Application no: 20/00466/DISC

Proposal: Discharge of Condition 17 (surface water drainage plan) of 19/00607/F

Location: Land At Skimmingdish Lane And Land And Roundabout At, Bicester Road, Launton

Lead Local Flood Authority

Scale(s)	1:250	ELR - Project Chainage (Miles Yards)	XX - A1	Sheet	1 of 3
Design Package Risk Classification	Normal			Revision	B01
Alternative Reference					
Drawing Number	133735_RW-EWR-XX-A1-DR-DH-001101

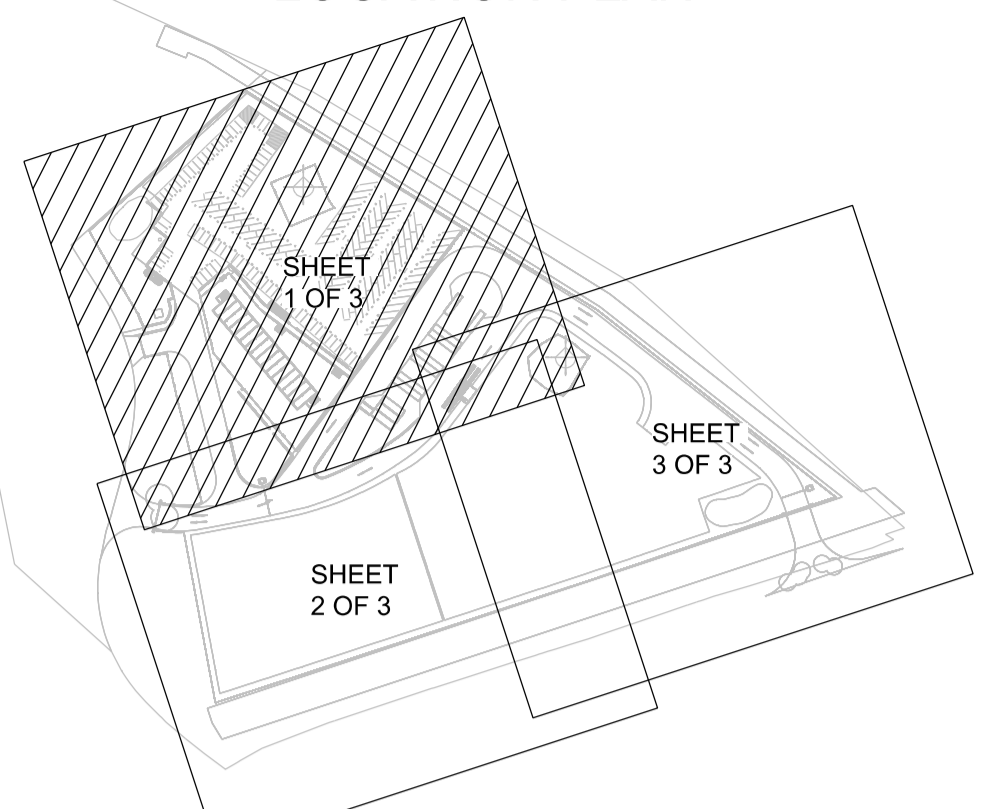
The main issue is that a pumped solution is proposed. Inline with the guidance, a pumped solution is a last resort. It has been demonstrated that a gravity solution can be achieved but to reduce the land take of the basins, they have proposed to make them deeper and pump them. This is not acceptable. There seems to be space in the layout to provide shallower basins.

If a pumped solution is required then in line with our guidance, 50% extra storage must be provided.

The correct climate change allowance of 10% needs to be used.
